HINCKLEY NATIONAL RAIL FREIGHT INTERCHANGE

Project reference TR050007

Applicant's Response to Deadline 4 Submissions [part 8 – Parish Councils]

9 February 2024

Figure 11.12: Night-time Views and Photomontages PVP 25

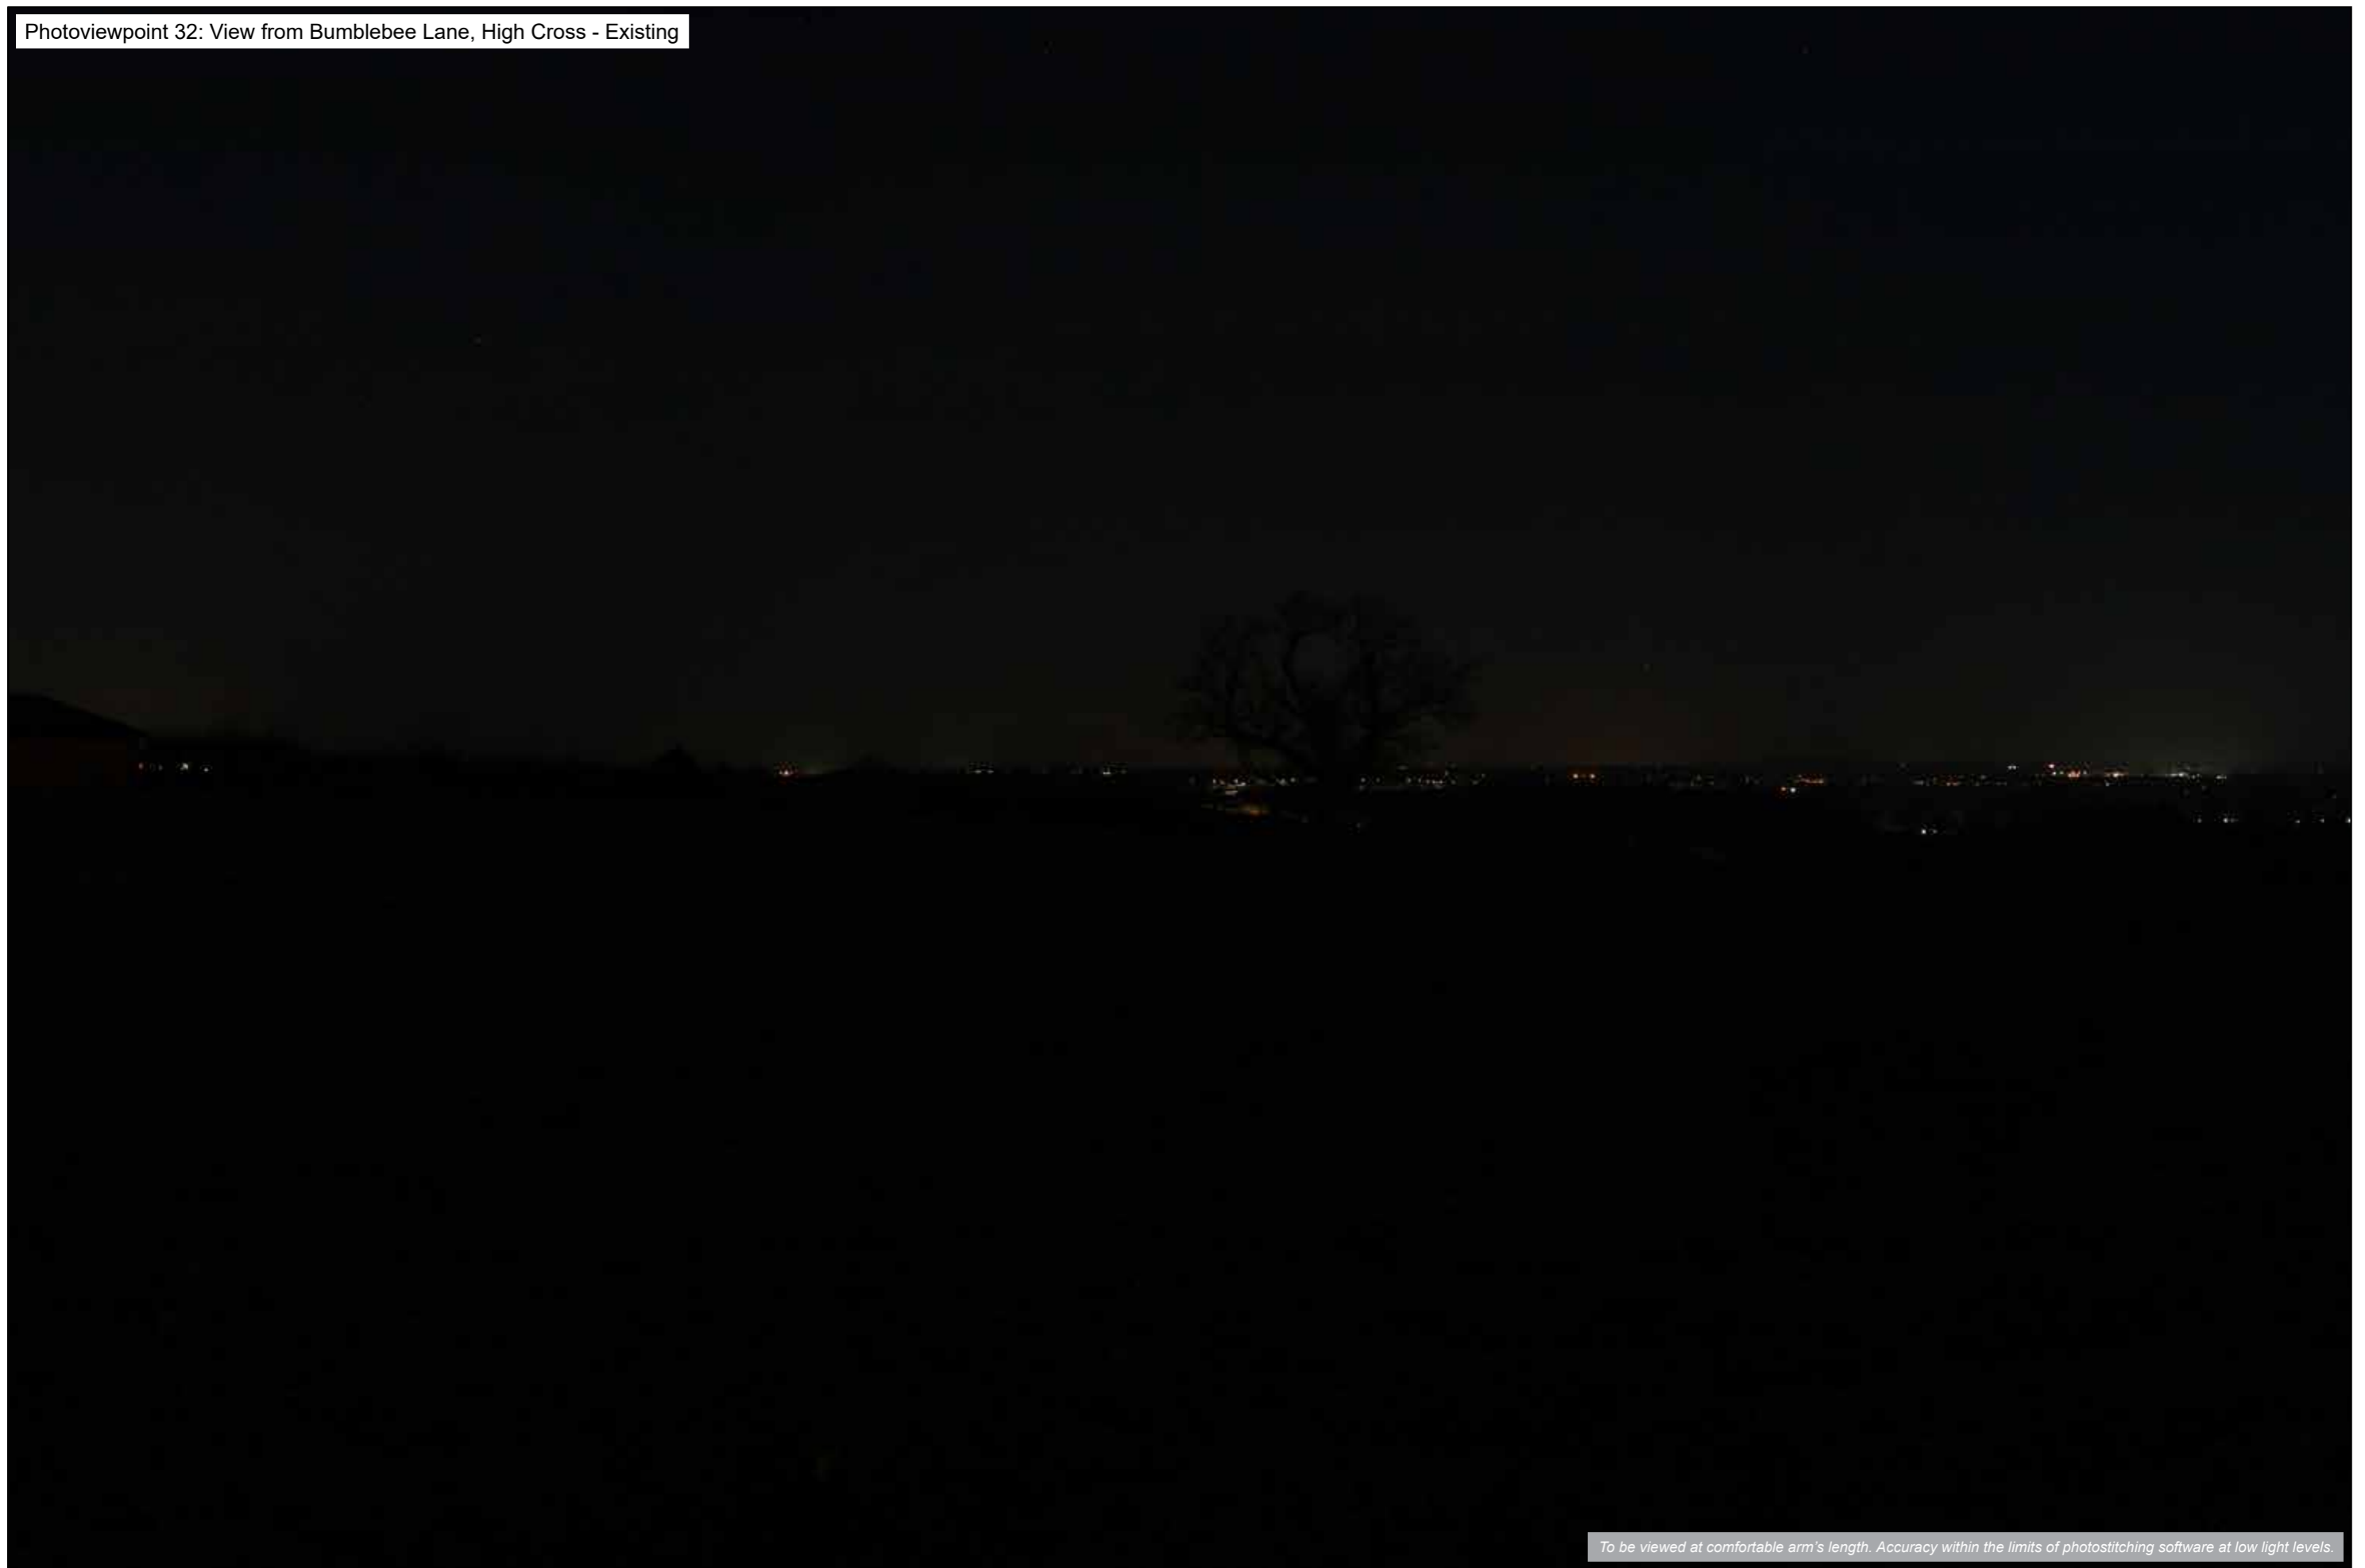
17	5.3		The quantum of lighting required is not diminutive. It will expand the existing lighting further into the dark sky of the area, adding to the substantive lighting proposed for the main employment site. This additional impact will affect the landscaping and ecology	The M69 slip road with lighting has been modelled in updated Figure 11.12 (document reference: 6.3.11.12A, REP4-076) at Photoviewpoint 12 and the Landscape and Visual Impact Assessment has been updated at paragraph 11.181. The night-time assessment
